Environmental Health Consultation Response		Officer	Michaela Gleave
Detail: construction of single storey extension at rear, including re-installation of ac unit			043936
Address:	Romeros, 37 King Street, Whalley		
Application Ref:	3/2020/0385	Case Officer:	Mr Stephen Kilmartin
Response Ref:	3/2020/0385/ENV/01	Issue Date:	15 th June 2020

PROPOSED REAR ELEVATION.

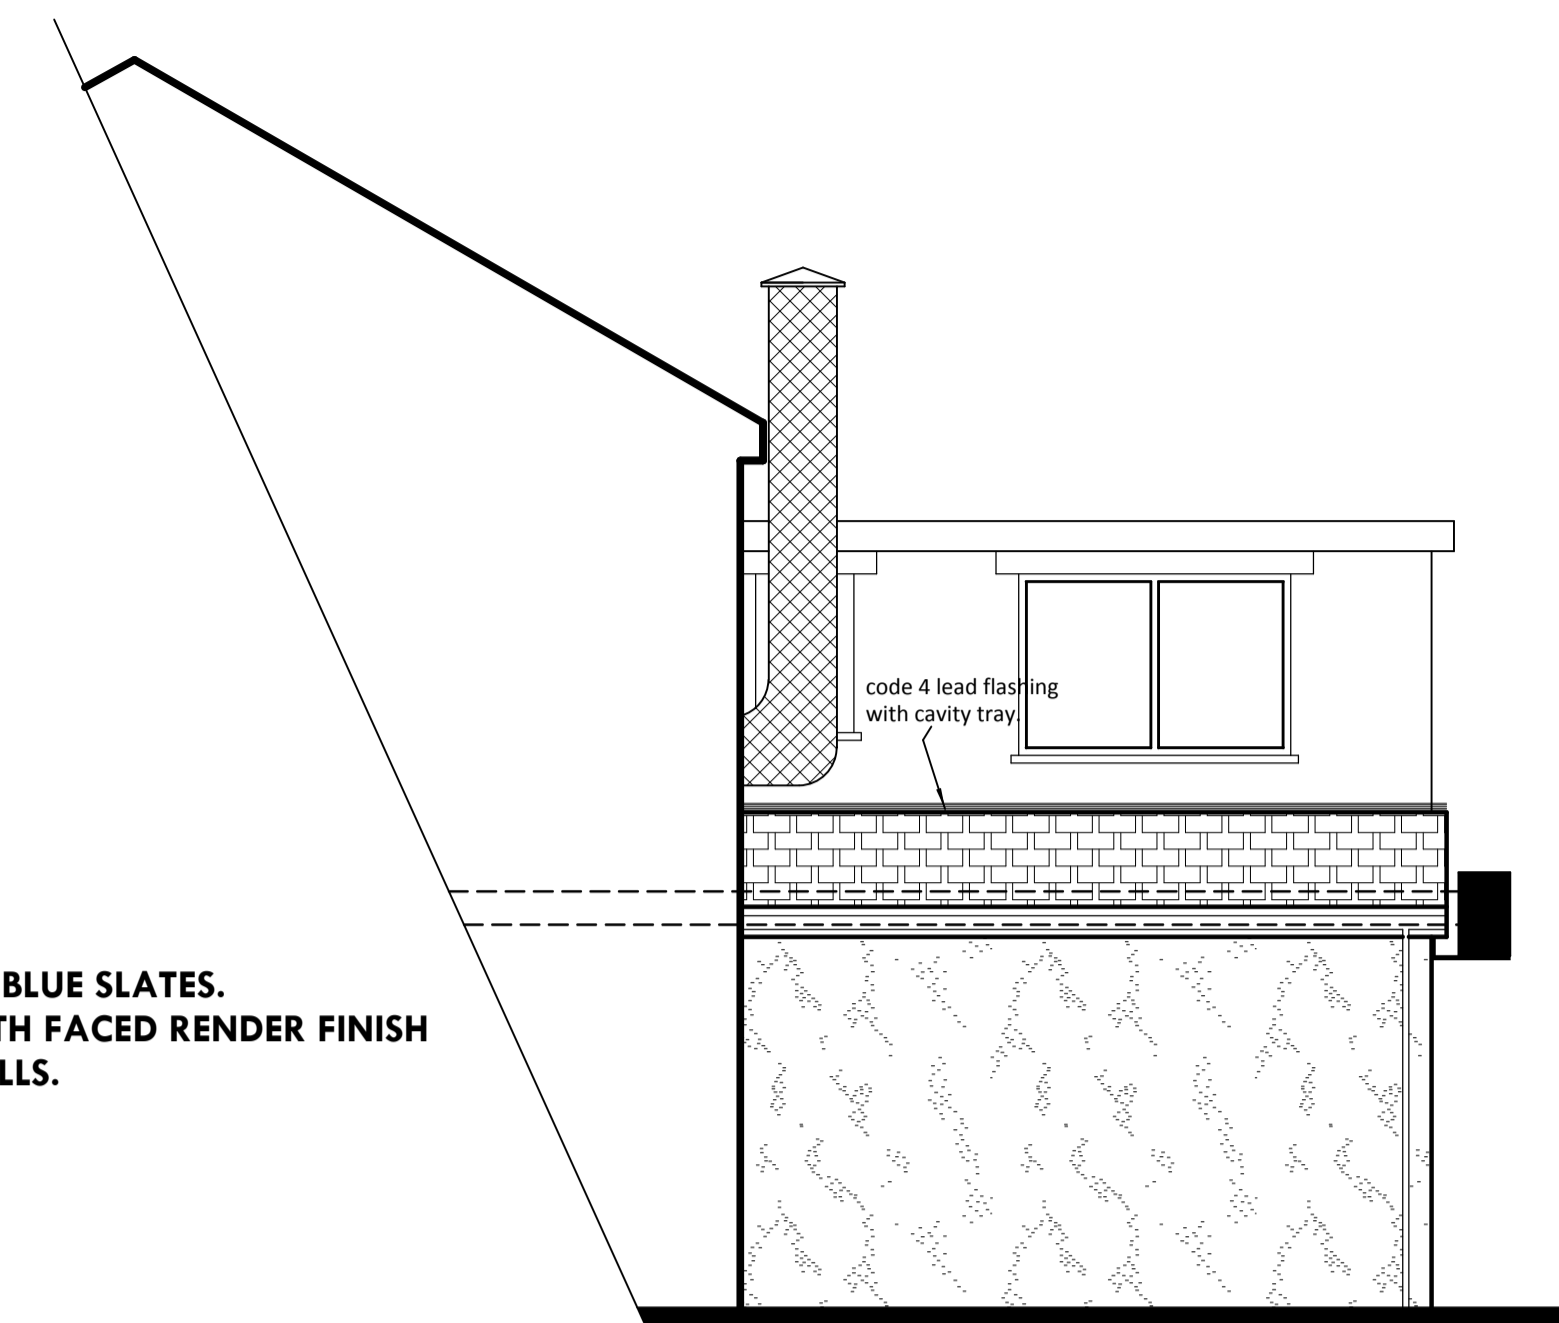
General Comments/Observations	
<p>1.1</p> <p>1.2</p>	<p>I have reviewed the above noted application and the observations have been provided on the basis of the level of information submitted and the comments contained within this response represent officer opinion only, at the time of writing, without prejudice.</p> <p>Although I do not wish to see a noise impact assessment for this existing development, in order to prevent any future adverse impact due to noise, I would recommend that the noise condition below is made.</p>
Suggested Conditions	
<p>1.3</p>	<p>Should you be minded to approve the application, notwithstanding other considerations, I would recommend that the following condition be attached, in case the unit is renewed rather than re-installed, should you feel it is relevant and justified:</p> <p>Condition 01 The Rating Levels for cumulative noise from all plant and machinery associated with the development shall not exceed the existing background noise level (LA90) at the external façade of the nearest noise sensitive premises, as assessed in accordance with British Standard 4142 (2014) or any subsequent replacement national standards. Alternative levels and monitoring locations may be used subject to the prior written approval of the Local Planning Authority.</p>
